WALBERTON PARISH COUNCIL

Planning Application WA/30/08 – Nettlecoombe, Wandleys Lane
Various extensions.

This Council has carefully considered the above application and wishes to register an **objection**.

West & South Elevations

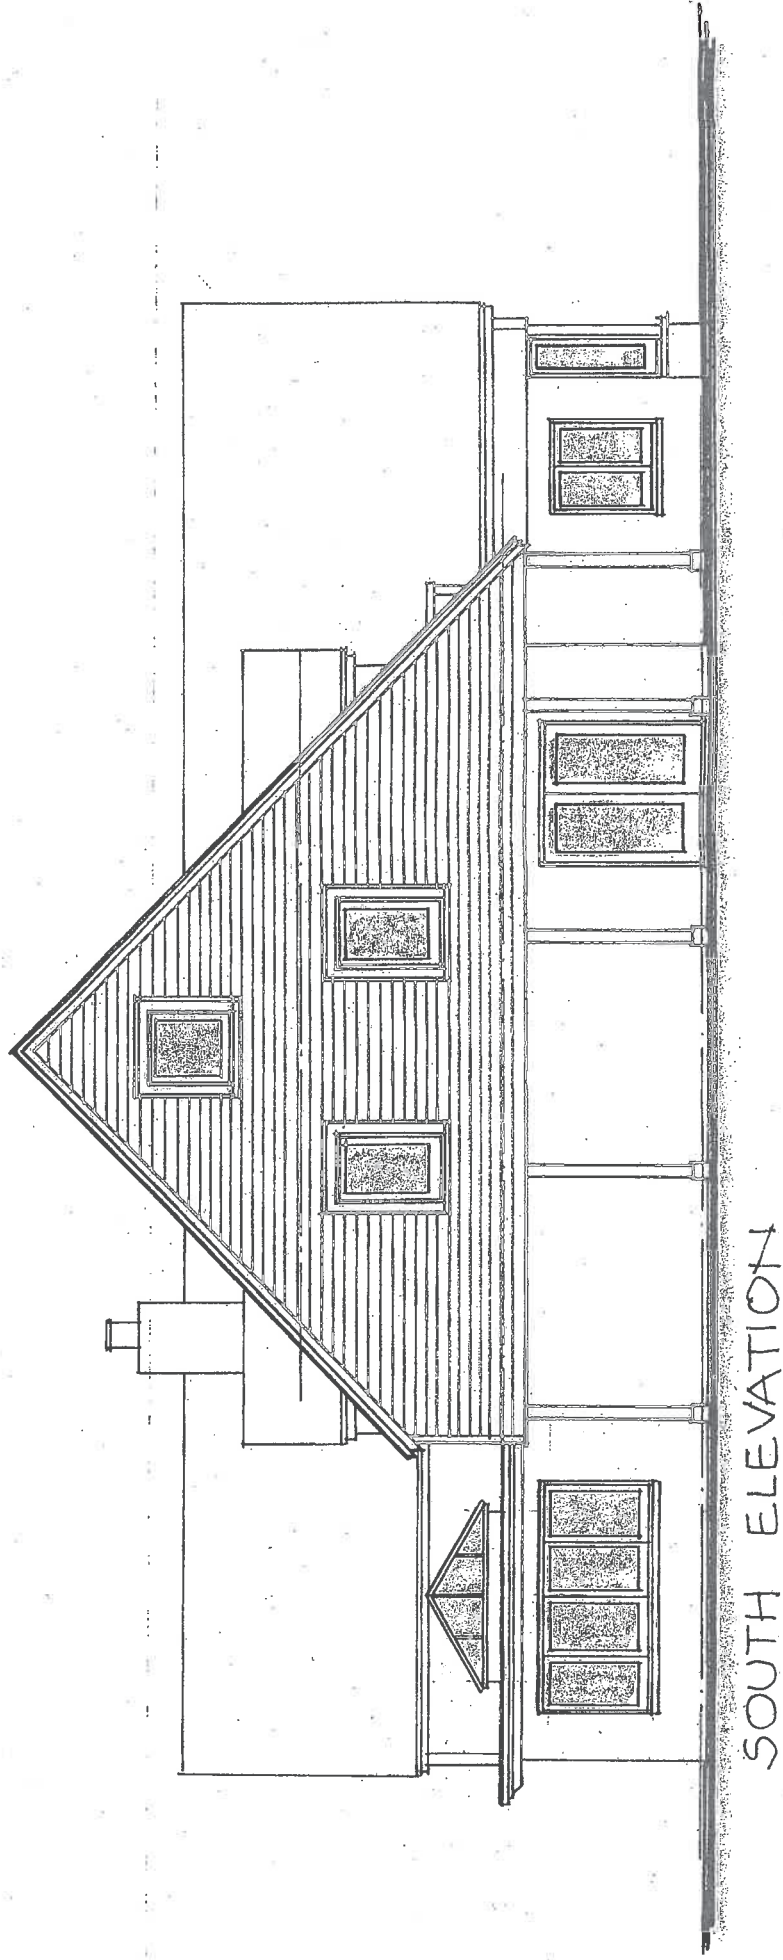
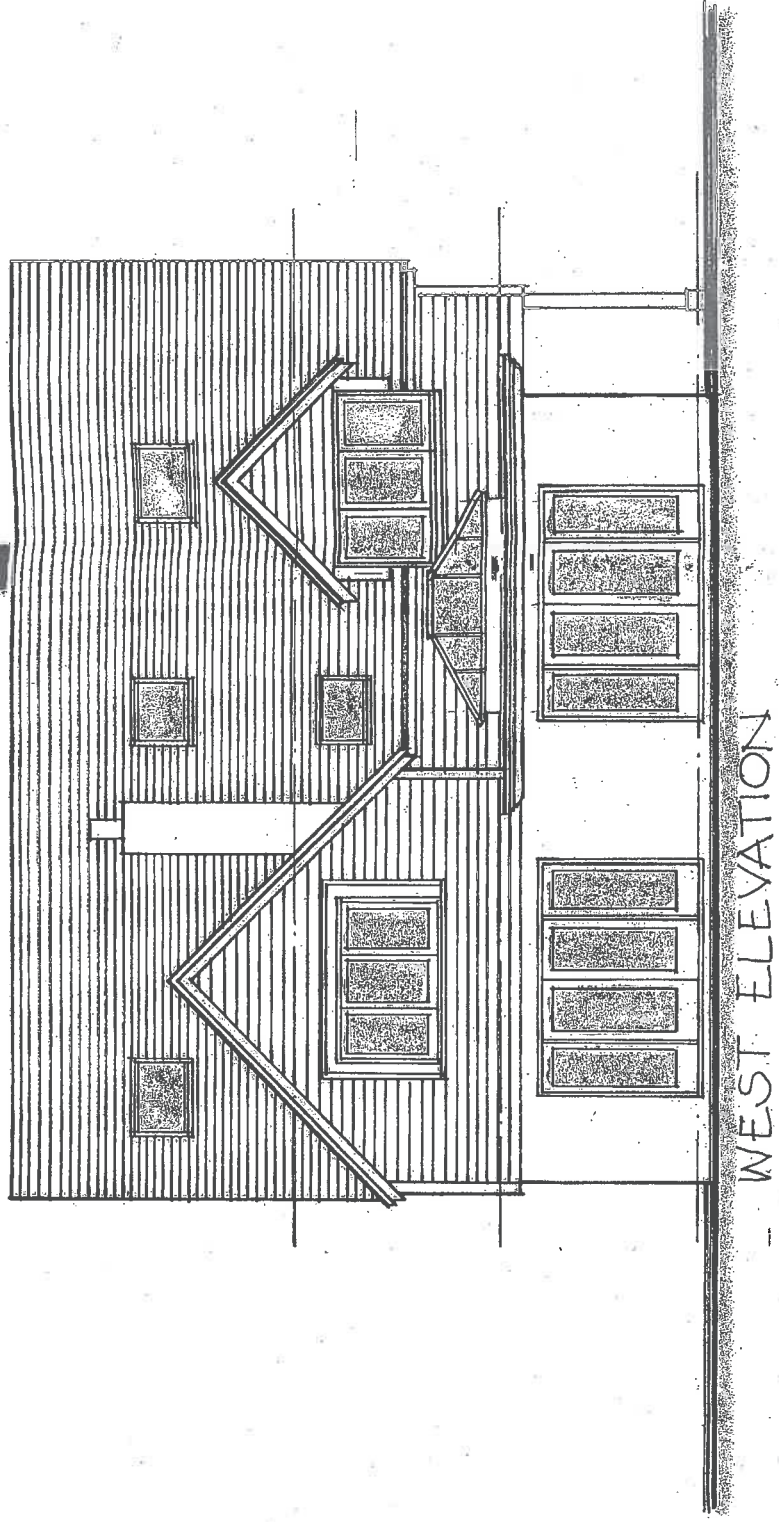
Whilst the Council has no problem with the two single storey extensions to front and rear, the design proposed for the additional floors is considered to be unacceptable by virtue of its height, mass and design. Moreover, the resulting form would be overbearing and incongruous in the local environment; the first floor windows in the north elevation would overlook the neighbouring Oak Bank; and the development is in no way visually subservient to the original building as required.
